DEVELOPMENT REVIEW BOARD

Project Number: PR-2022-007588

Project Name: New Mexico Cancer Center

Request: Amendment to Site Plan – DRB

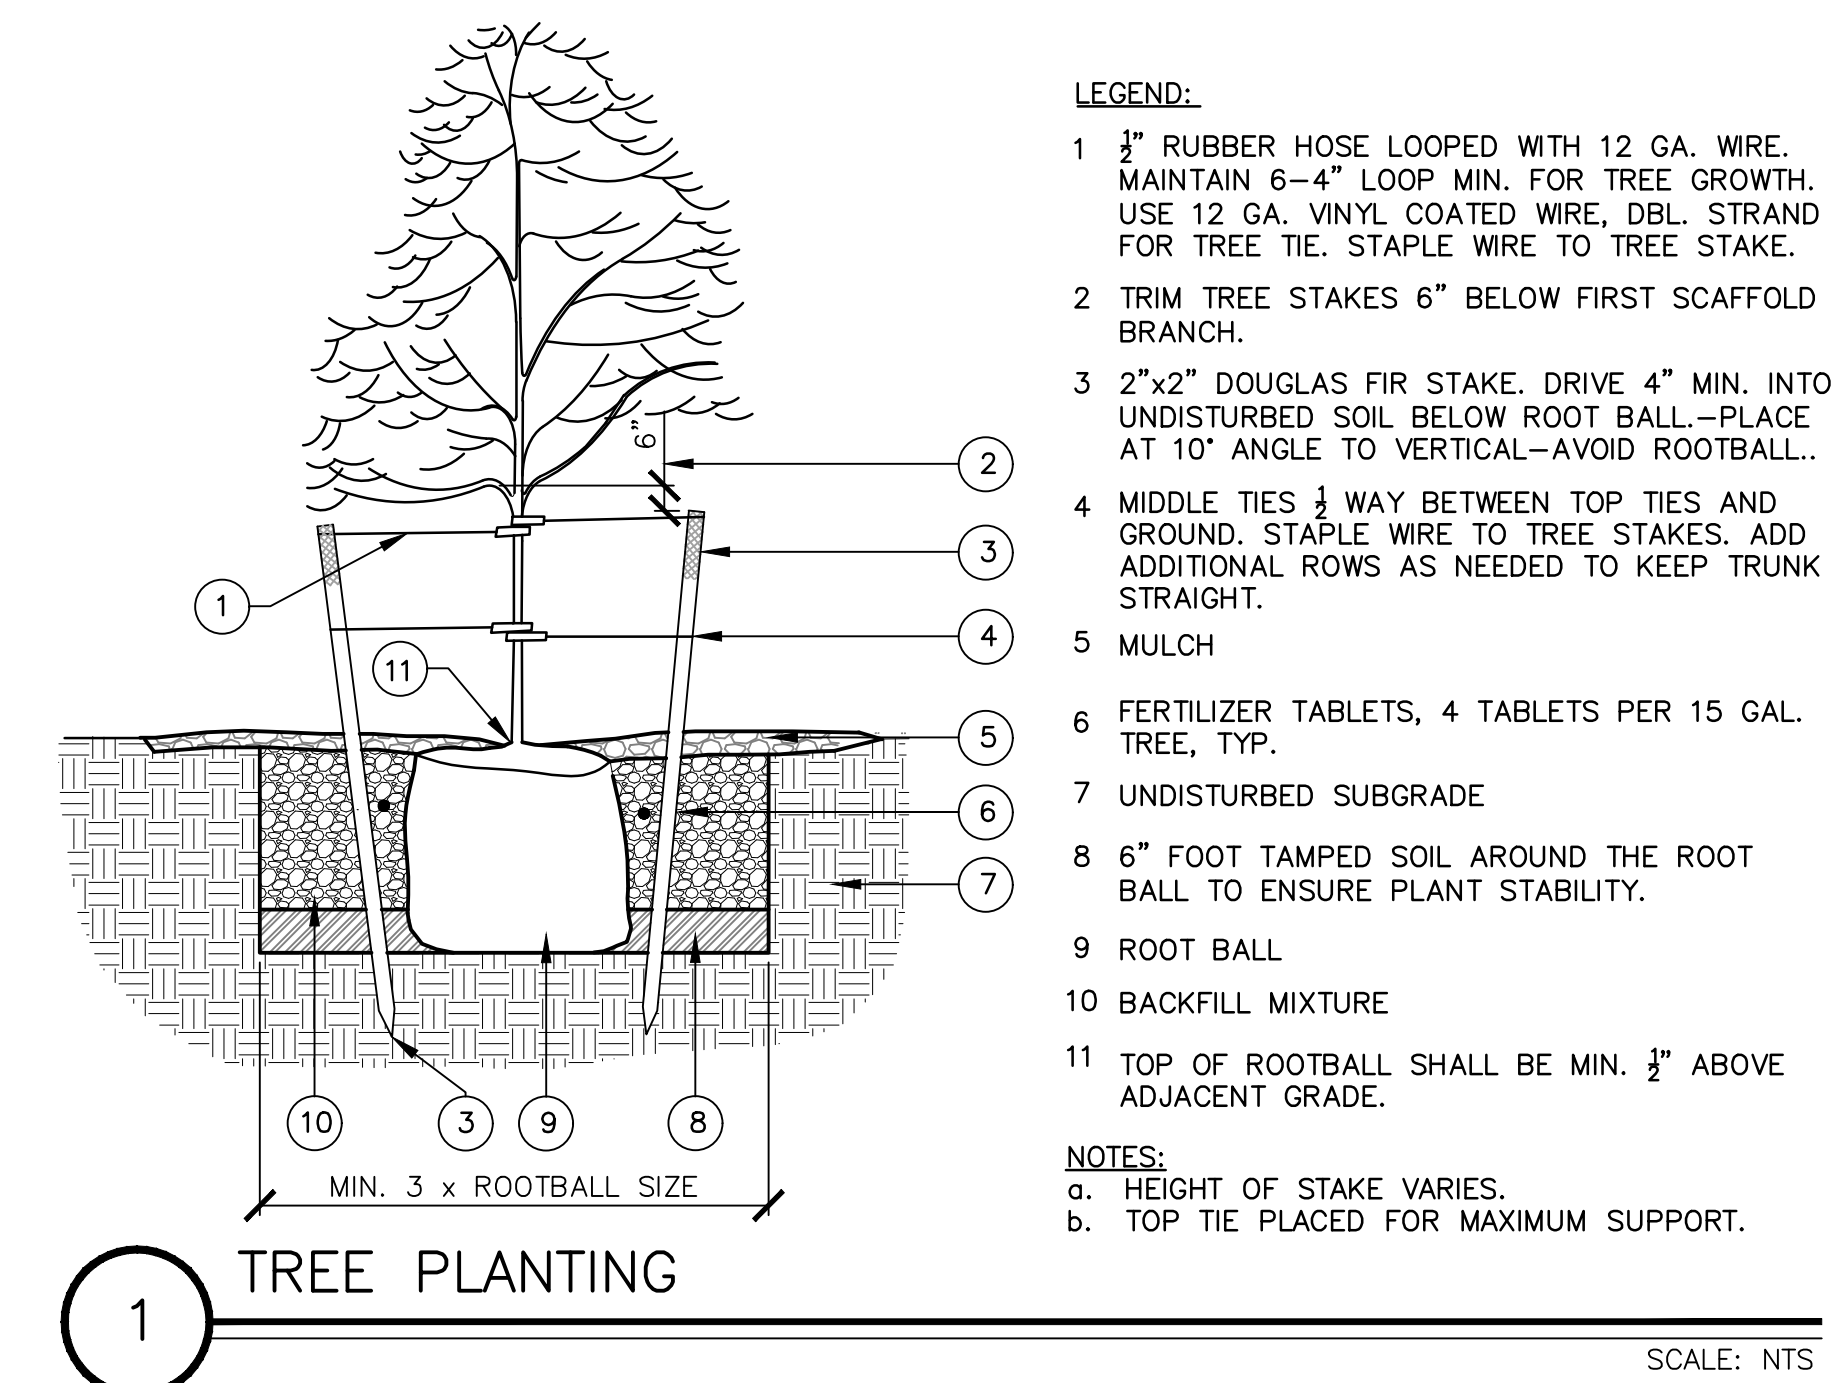
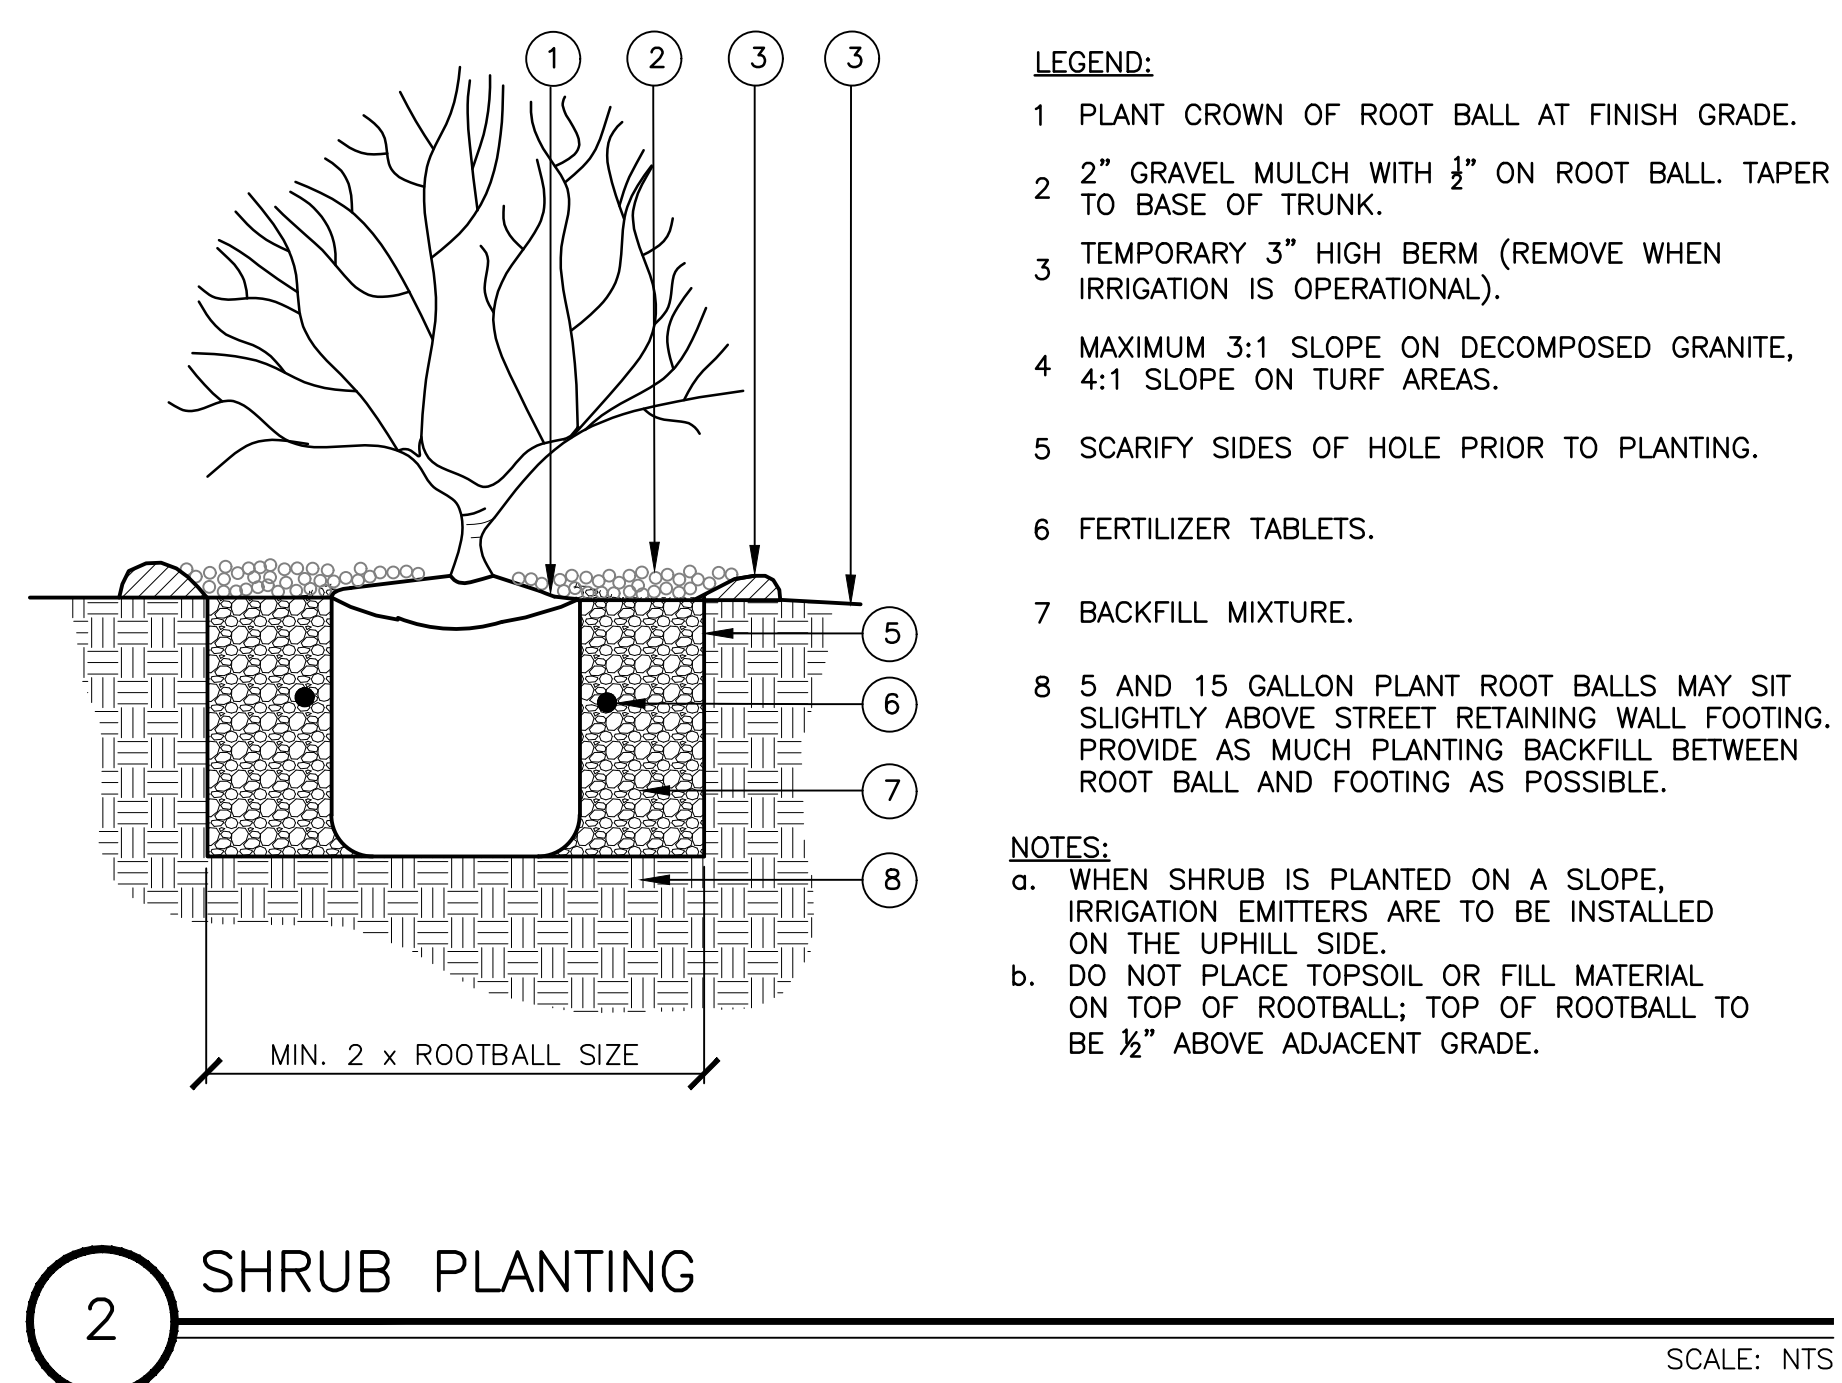
- Detail as to how the required number of motorcycle spaces (6 spaces) was calculated needs to be provided in the Parking Tabulation section.
- The Landscape Plan must meet the 15% net lot area landscaping requirement per 5-6(C)(2) of the IDO. Confirmation and calculations of this requirement must be provided on the Landscape Plan. (The plan sheet seems to state that the fire lane makes this requirement non-applicable, however staff is not able to confirm this per the IDO.)

- The Landscape Plan depicts the removal of two large Chinese Pistache trees from the parking area. Staff discourages the removal of mature trees from a development if there is a way to save them. Please explain and justify their removal.
